From: Paul Cann
Sent: 07 February 2018 12:06
To: Planning.Responses; Richard Temple
Cc: 'Robert Clark'
Subject: RE: Planning Consultation on EG/3/18/DOC

APPLICATION **EG/3/18/DOC**

Site Address: 15 Highview Road Eastergate PO20 3XB

Description of Works: Approval of details reserved by condition imposed under
EG/58/17/HH relating to condition No. 4 (Surface water
drainage)

Client	Mr and Mrs Stevens
Drawing Title	Surface Water Drainage

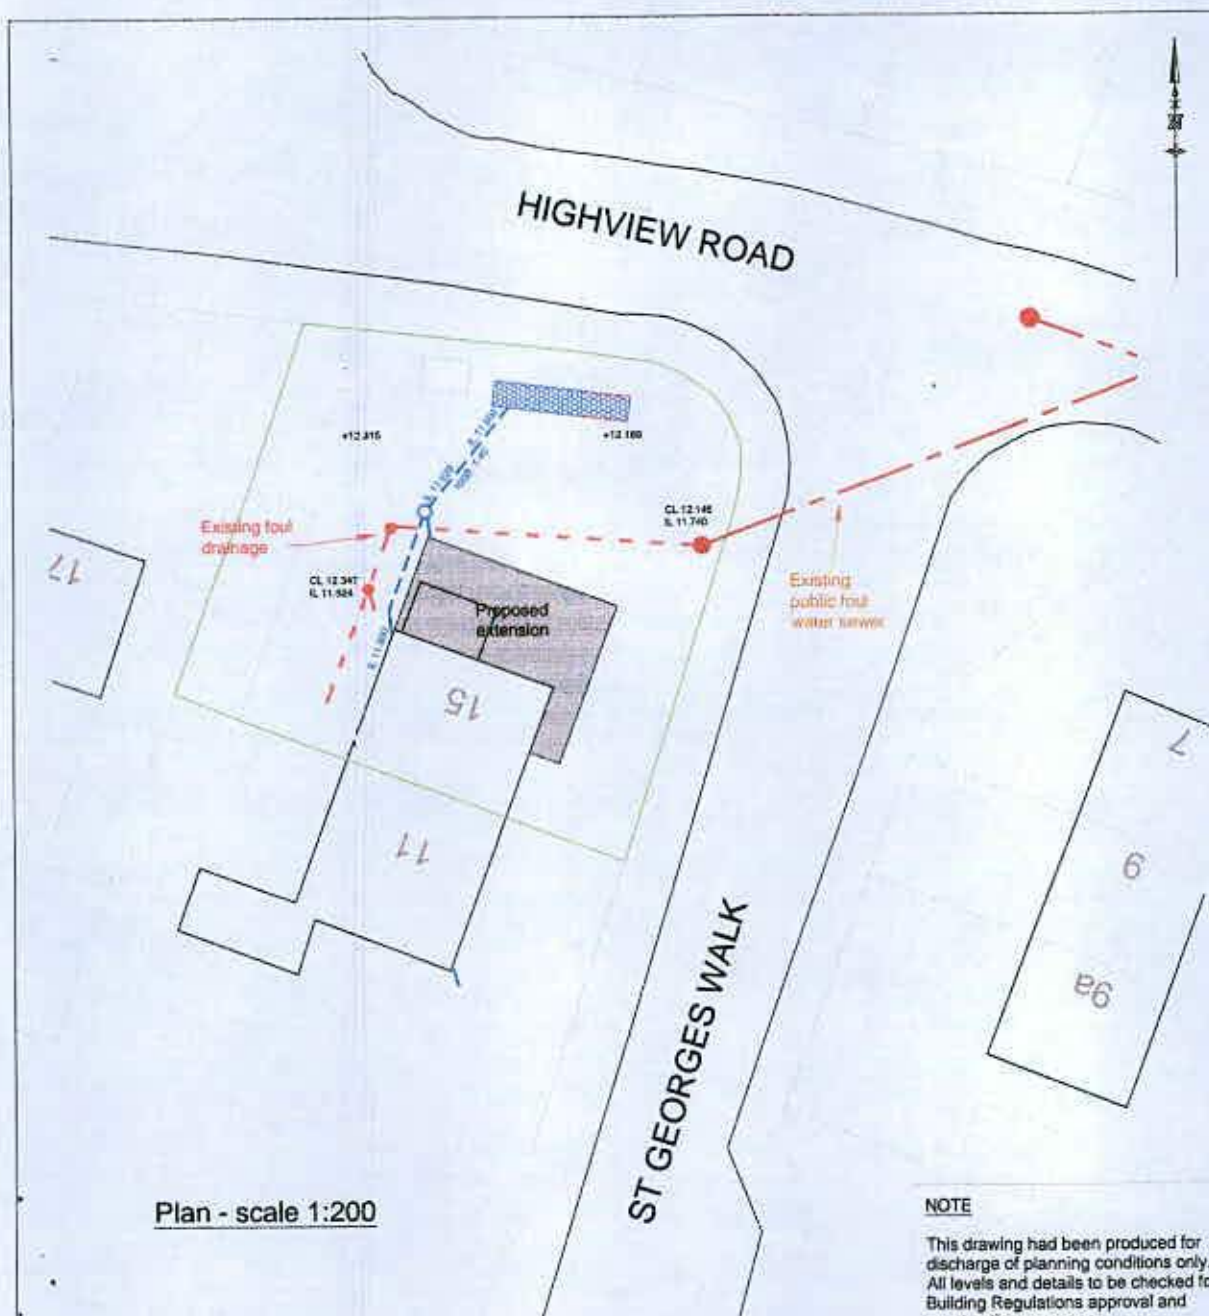
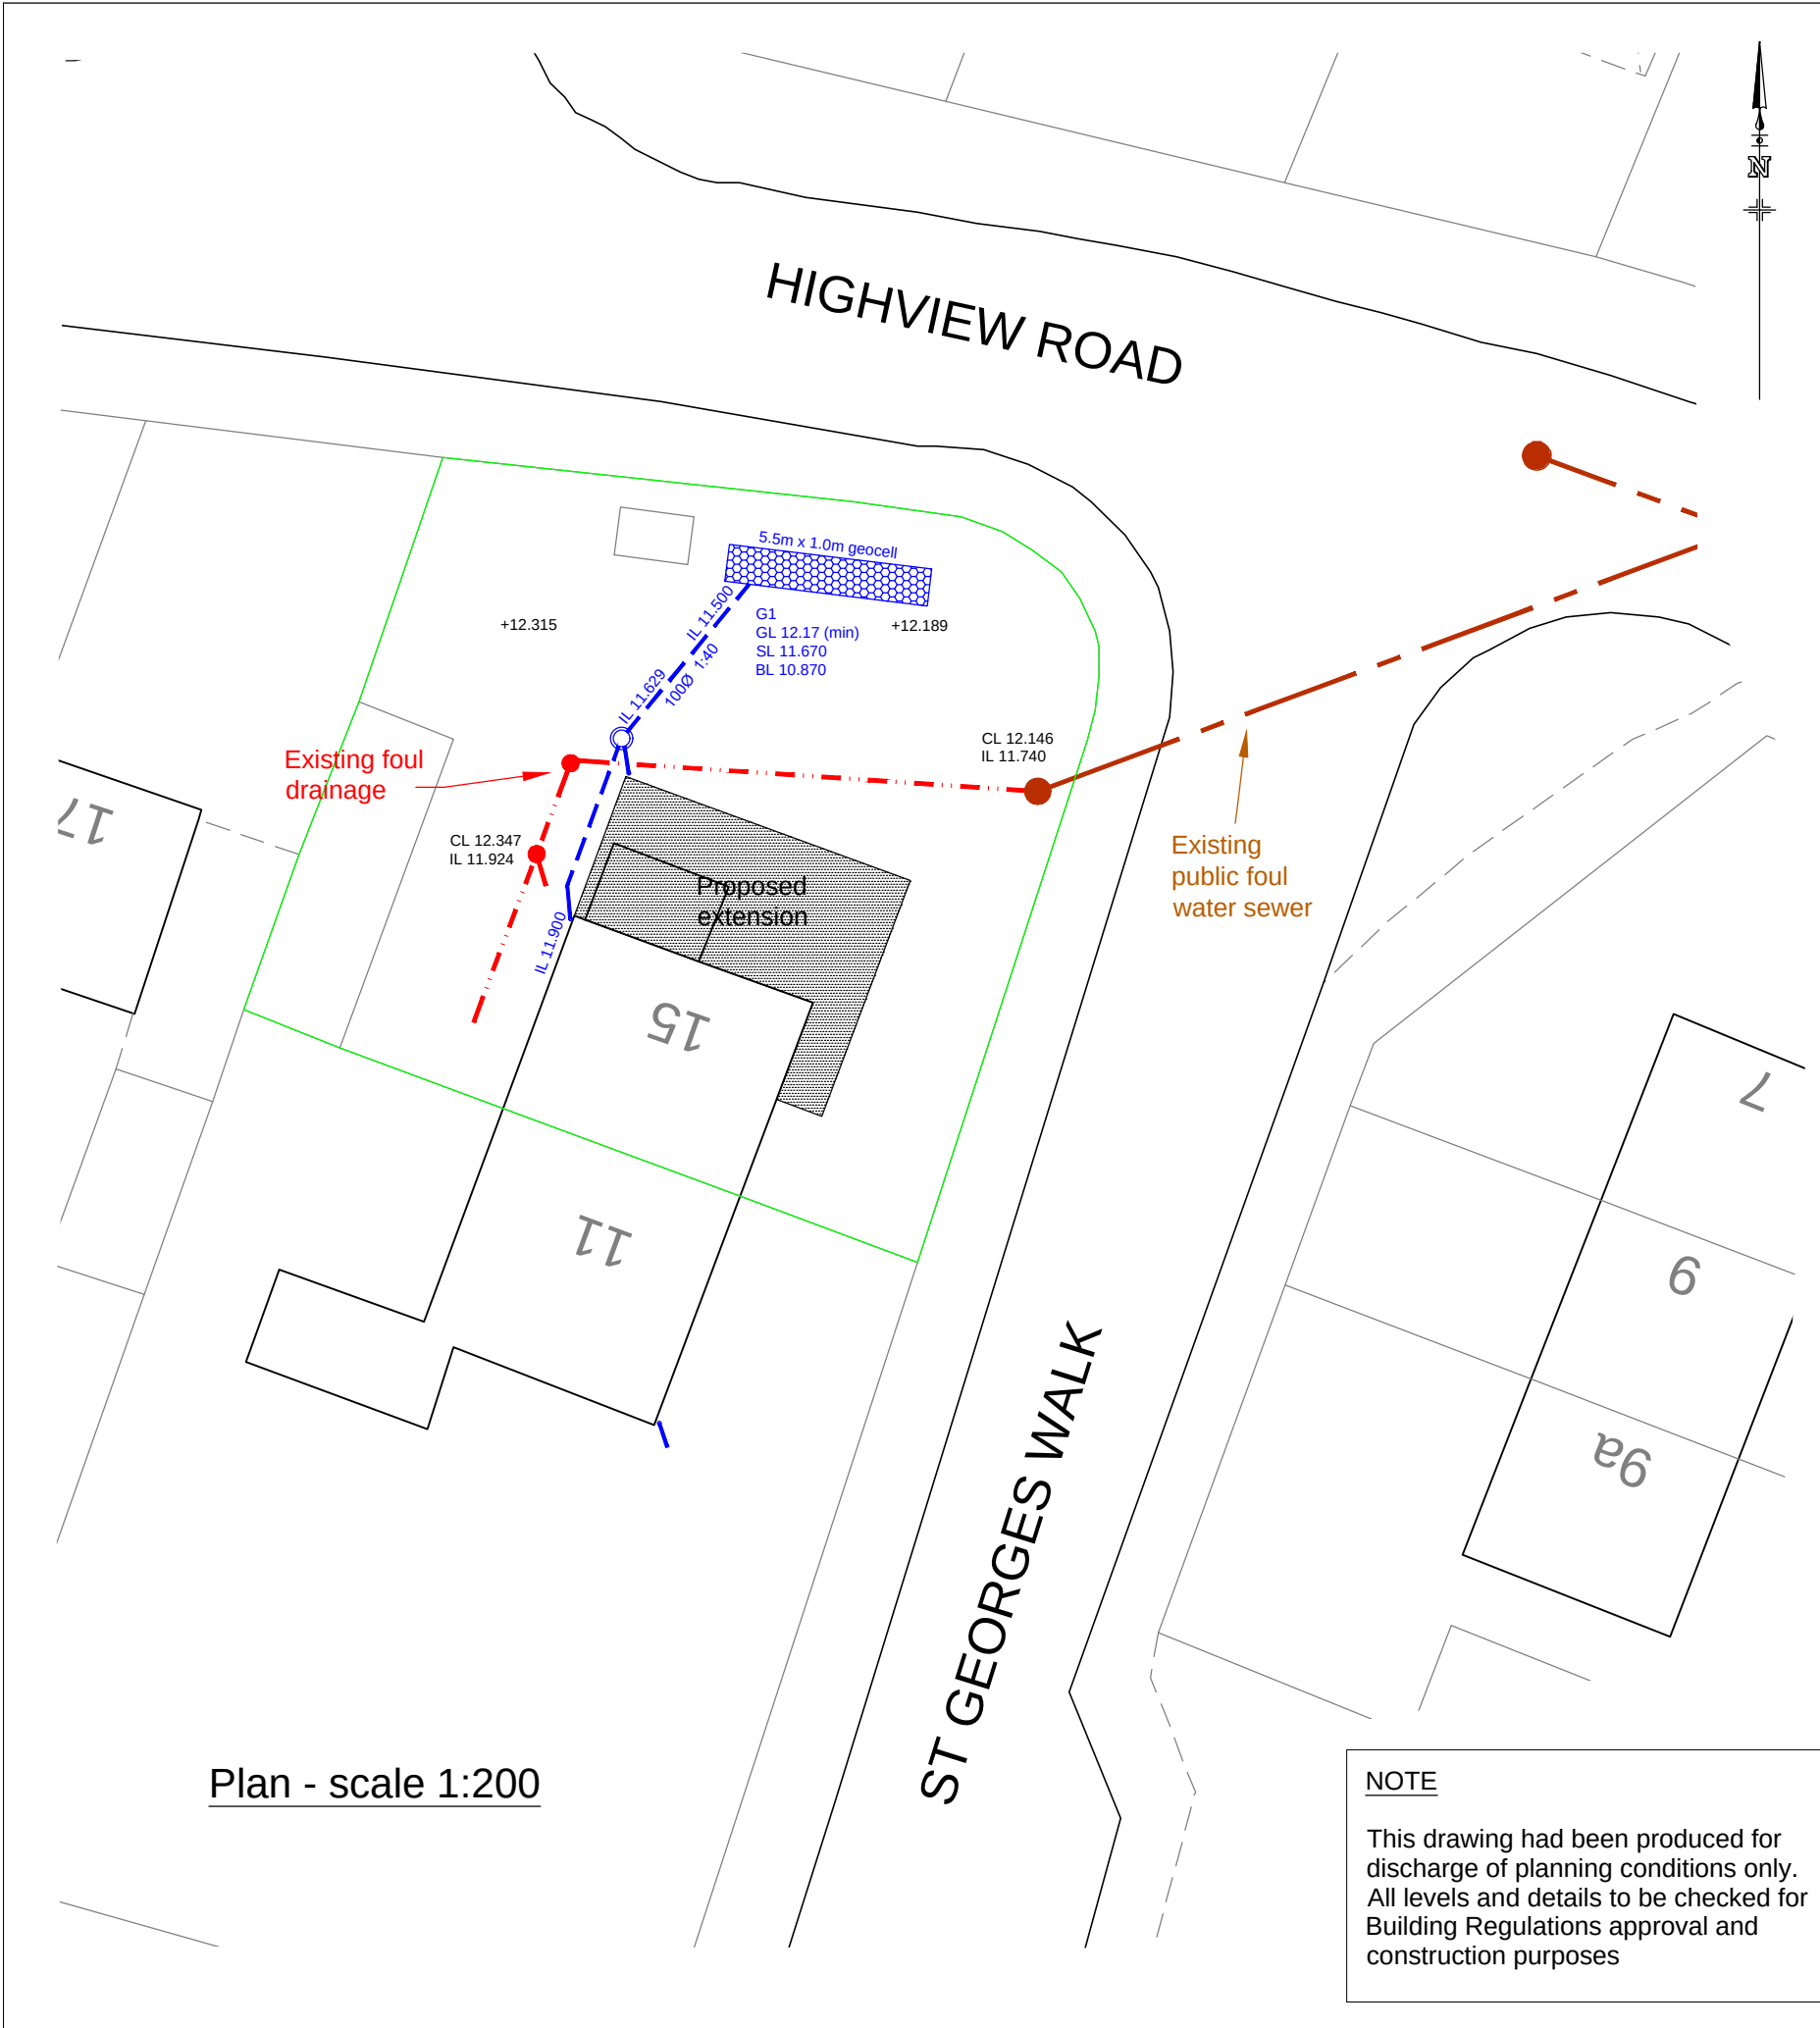
1. For clarity, on the layout drawing, please specify the base level of the crates and top of crate level.
2. Again for clarity, show dimensions for the length and width of the soakaway.

Based upon the revised drawing, the condition can now be discharged.

Amended plan attached as per your requirements, which I hope is all ok now.
